**ADC Planning Consultation
Response from the Historic Buildings Adviser**

Application Number	AB/100/11/L
Address	Newburgh House, Arundel
Description	New opening in wall between kitchen and living room.
Case Officer	Peter Cleveland
Site Visit

11395/ 02

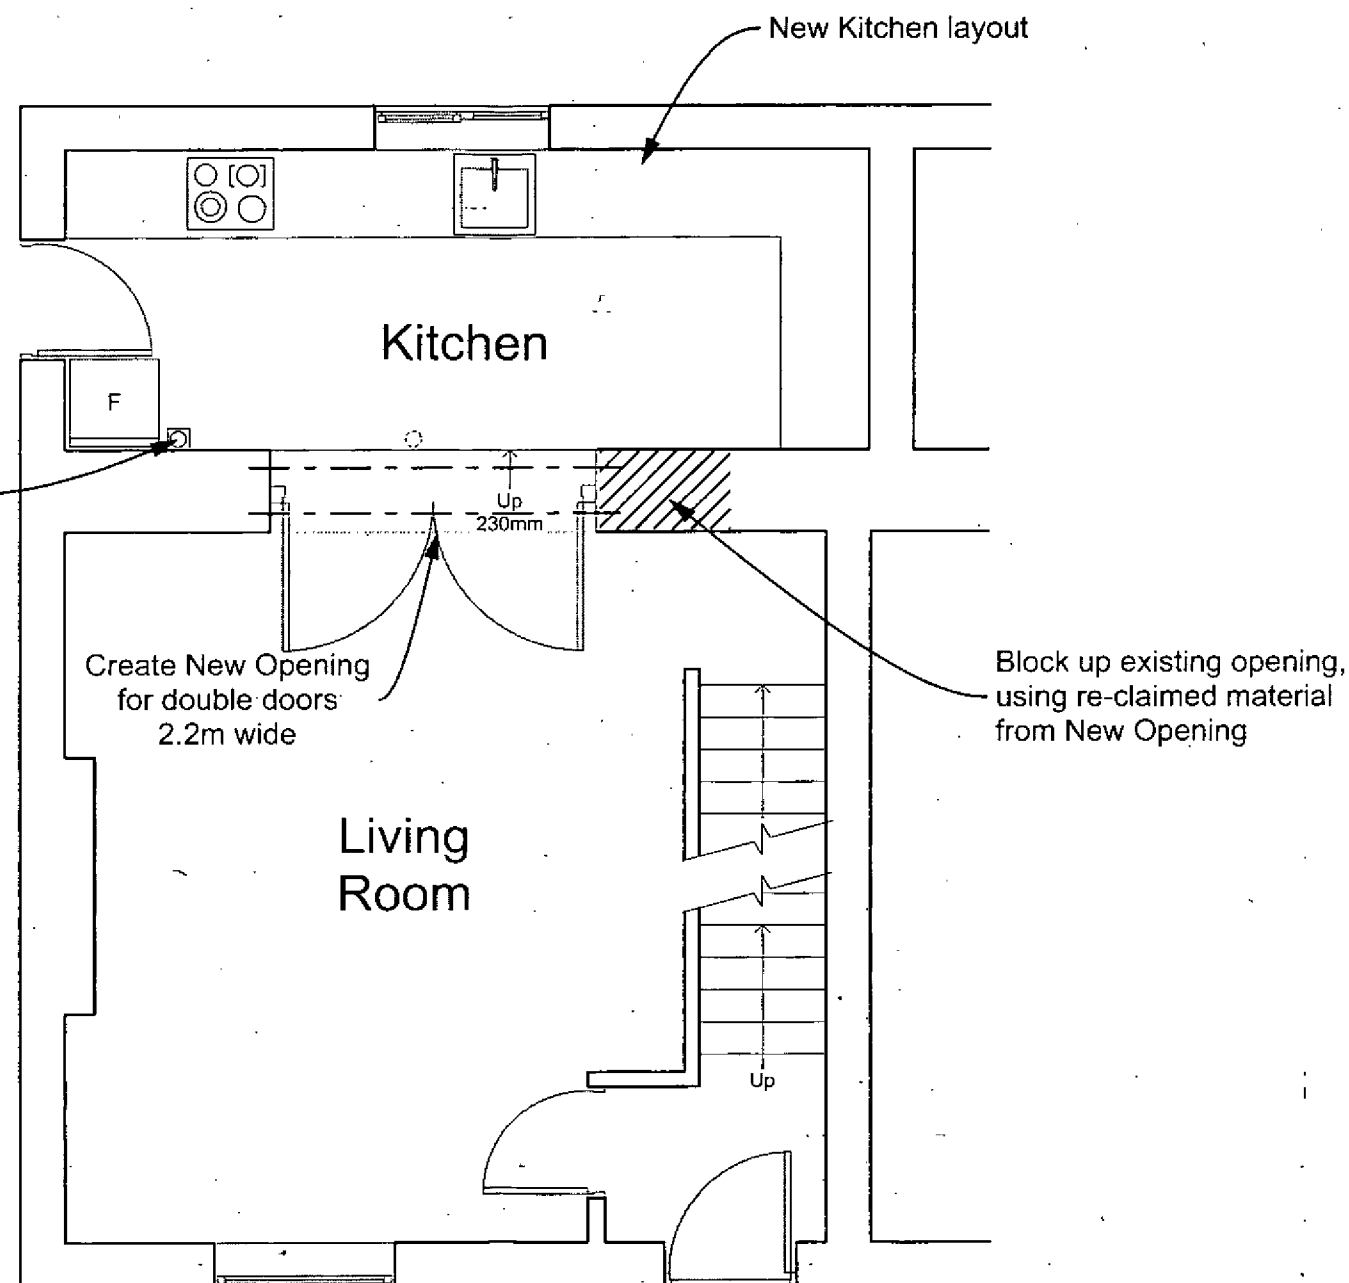
In this instance, a large amount of historic wall is being lost and the living room opened up into the kitchen. This is not sympathetic to the nature of an historic building, particularly a domestic one, or the function of these rooms; nor is it justified. Where harm is being caused in these instances, the main consideration must be justification. Policy HE9.1 of PPS 5 stipulates that:

11395/ 02

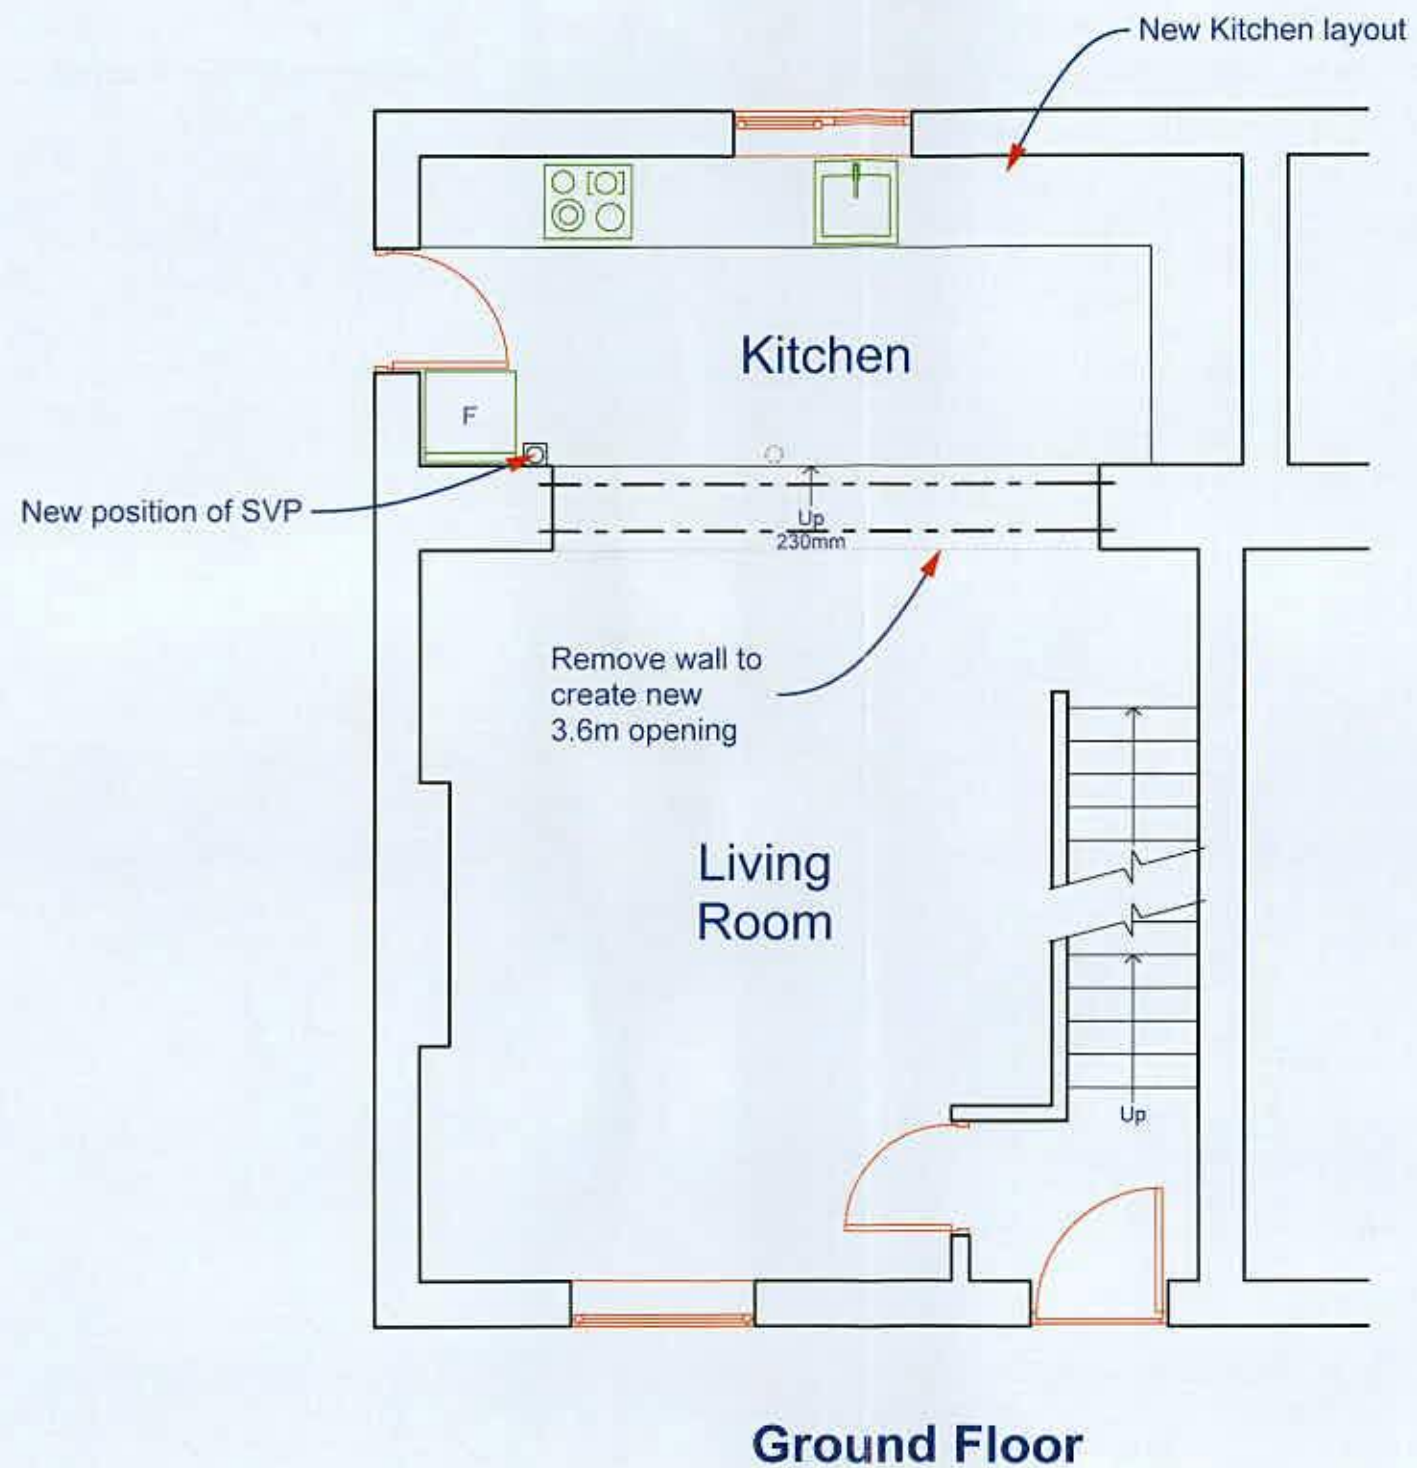
Whilst new internal openings in listed buildings can be acceptable, under PPS5 (2010), harm to a heritage asset may not be appropriate where excessive levels of historic fabric are being removed and where justification for that loss is not convincing.

This scheme is made more difficult by the proposal to remove a large section of former external wall. Whilst it is now viewed internally, a principal wall is always going to be integral to the original structure and an understanding of the building's earlier form and character.

On this basis and for the reasons above the scheme cannot be supported.
